Application for a Non-Material Amendment Following a Grant of Planning Permission

Erection of 2 additional storeys above existing level C to supply an additional oncology ward including skyways linking the additional floors to the main hospital and rooftop plant room.

22/00337/FUL

Drawing Title  
**Proposed South East Elevation 5**

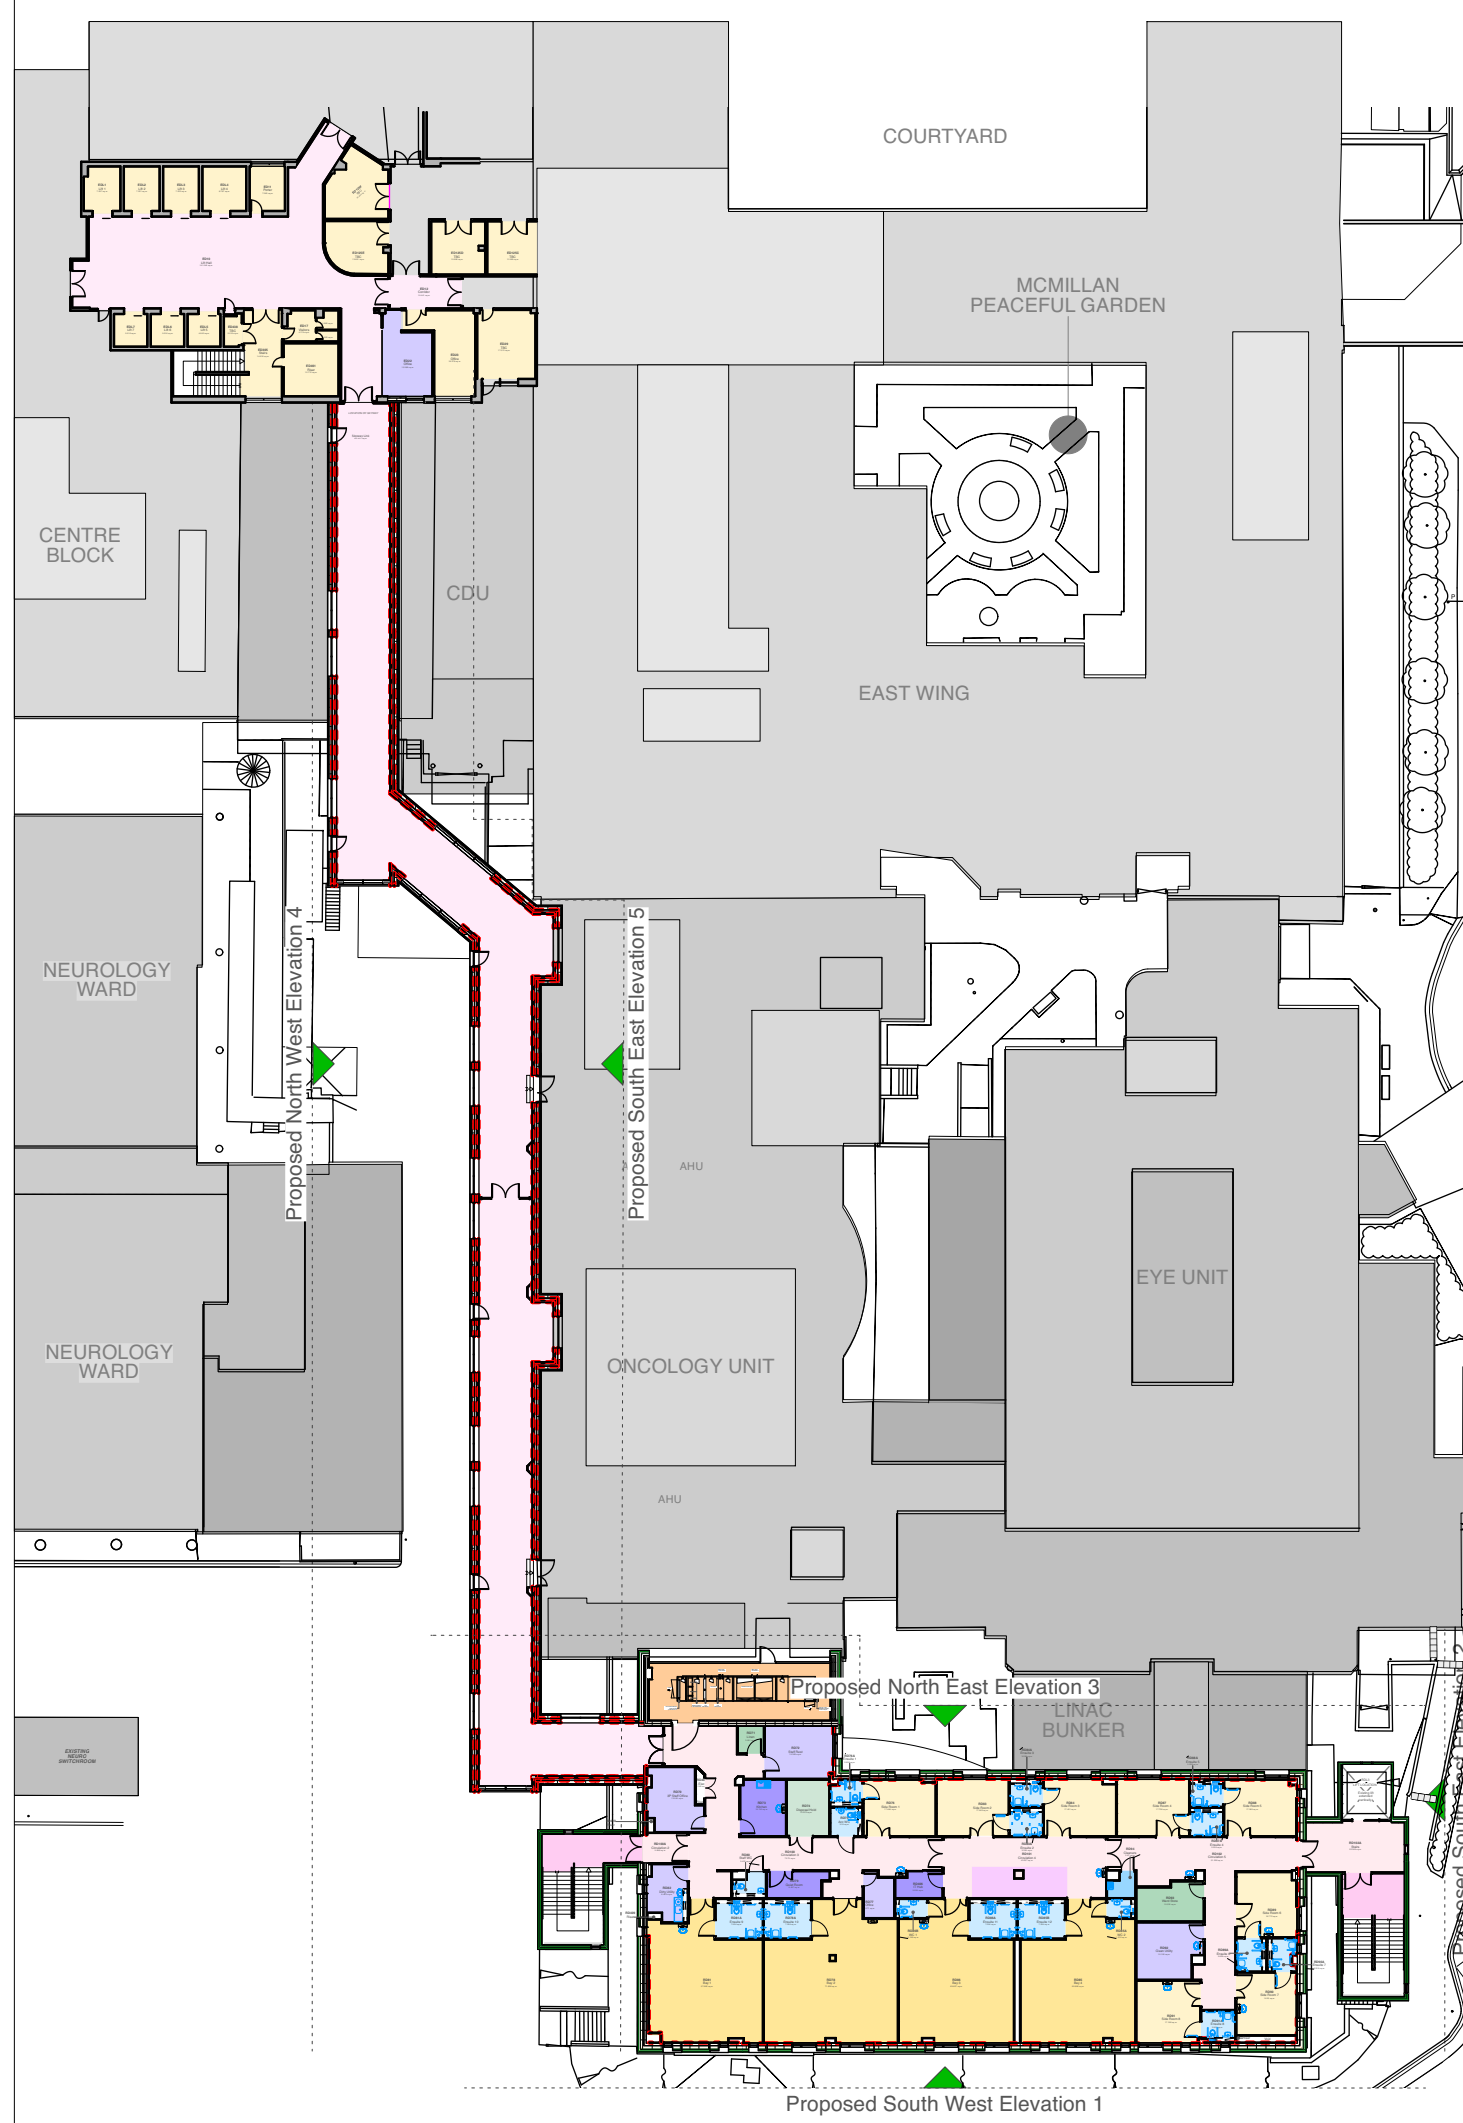
- The door from the centre block onto the roof (Level F) is omitted
- Gold feature banding added to the rear elevation of the link bridge
- The link bridge cladding colour changed to Anthracite Grey

Project: Proposed Vertical Extension Oncology  
Drawing Title: Proposed South West Elevation 1

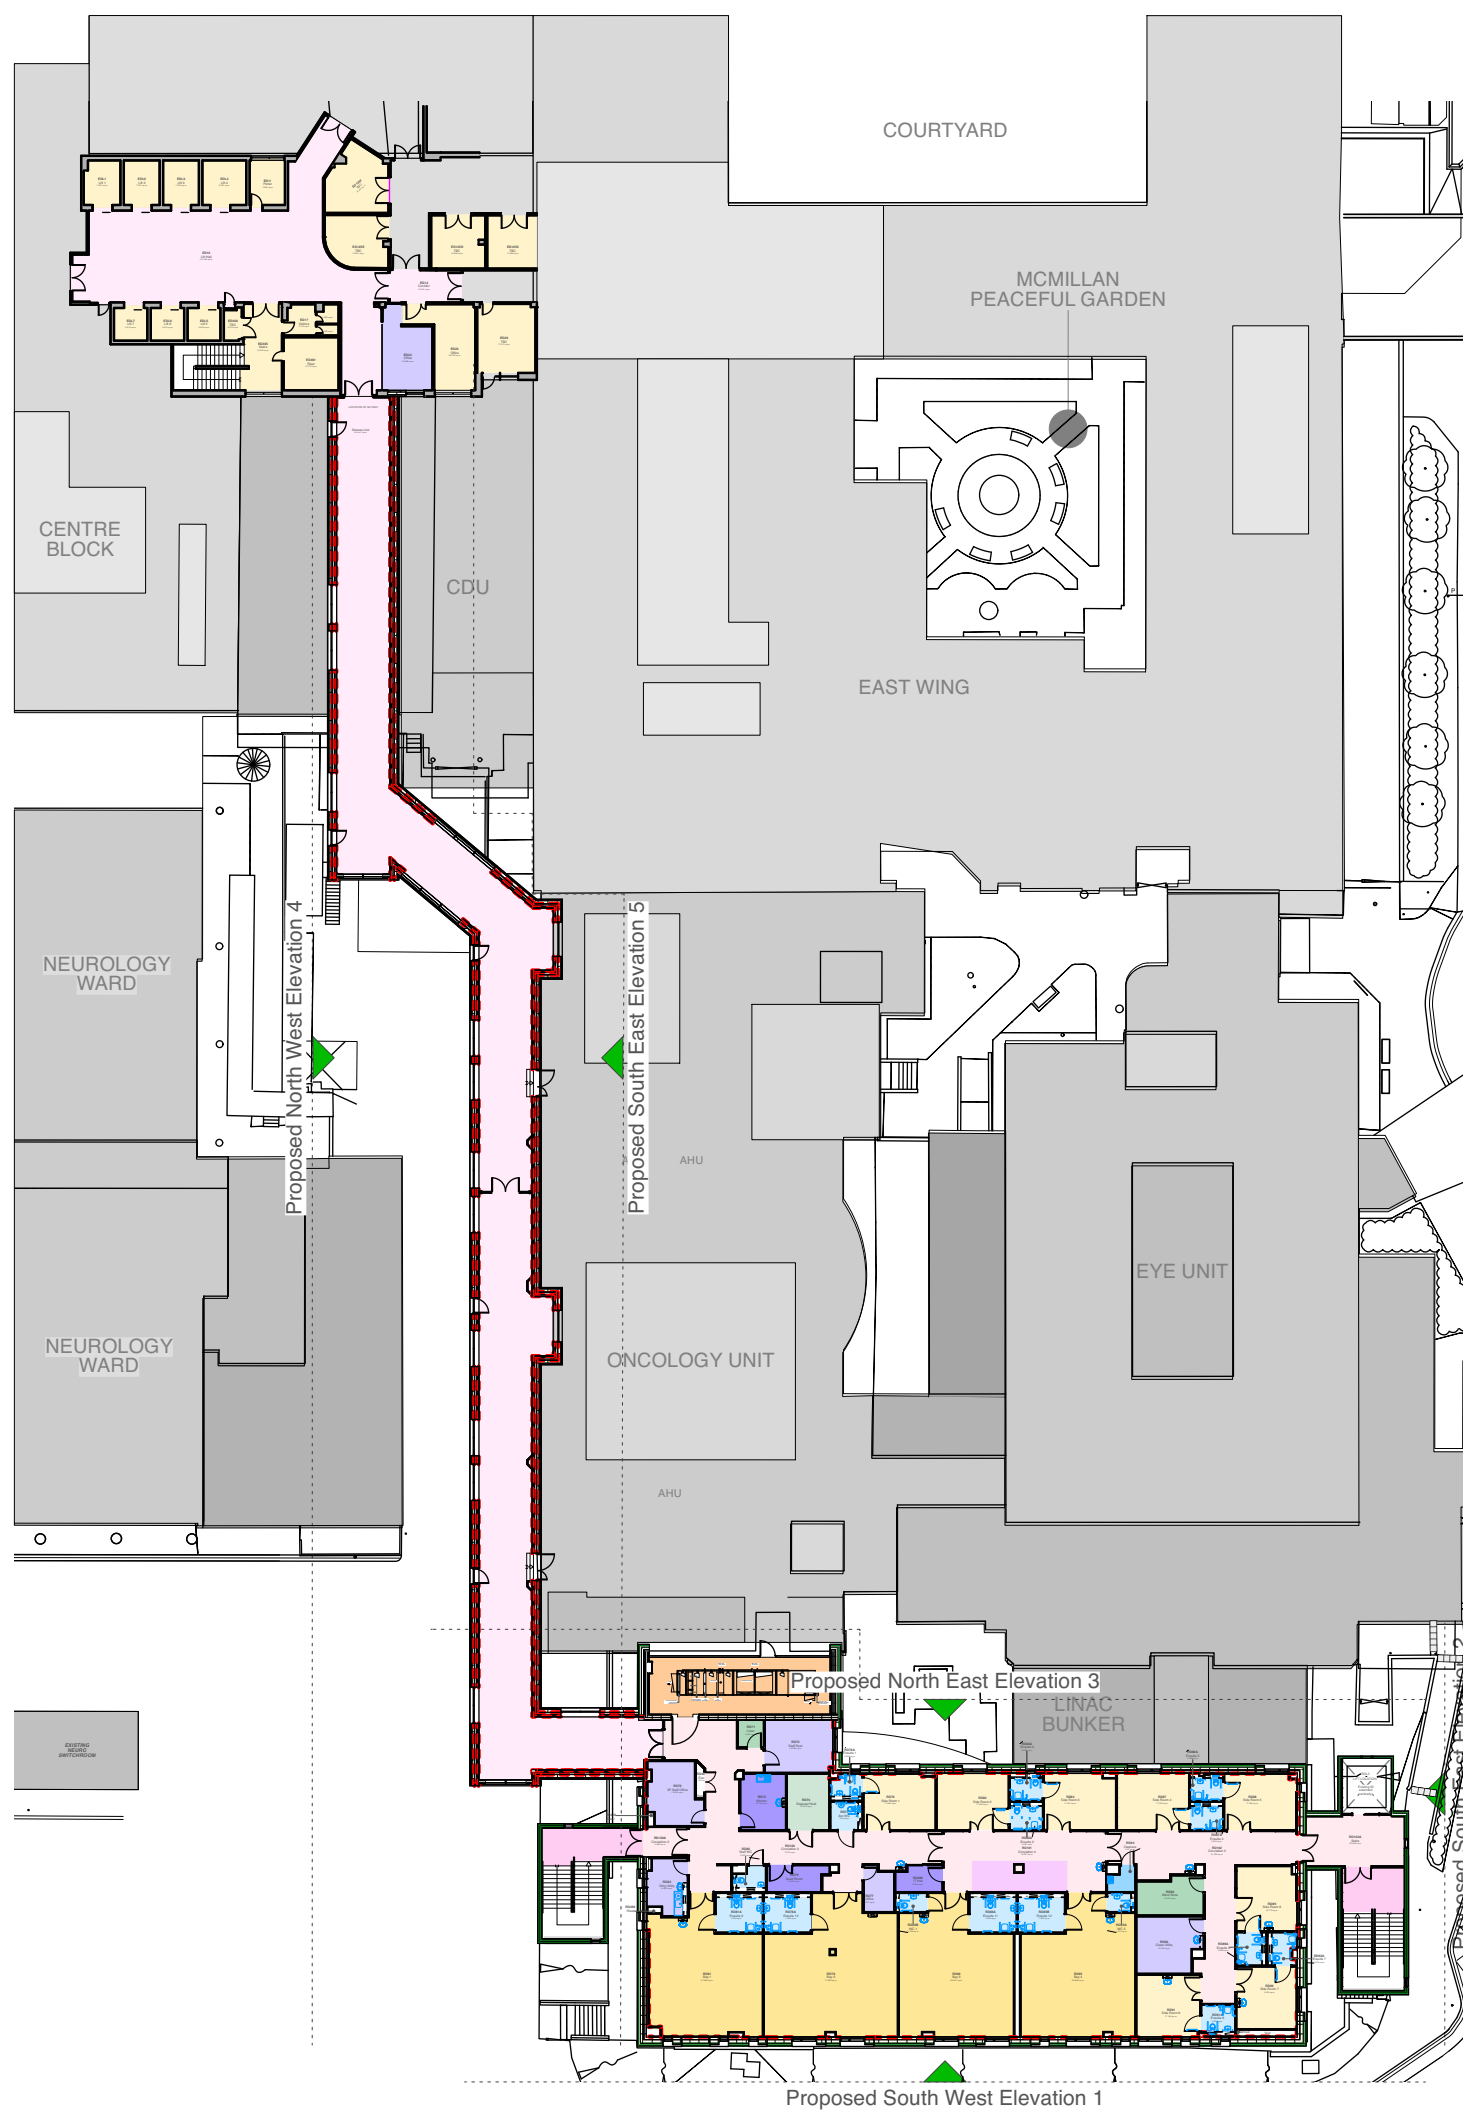
- A change from louvres to windows in the exit stairwells
- Additional plant space on Level F
- Curtain walling removed from the link into Oncology, windows on northeast elevation replacing the CW.

Drawing Title: Existing Roof Plan

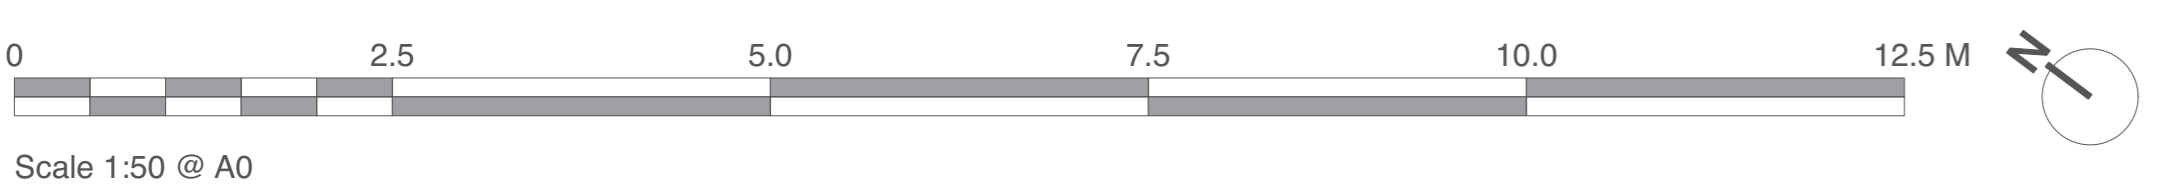
- DB cupboard added on Level E
- Roof step-over added from skyway to oncology plant roof
- All window projections omitted from the link bridge
- Level D doors from link bridge onto existing roof moved, 'seating projections' added over existing roof
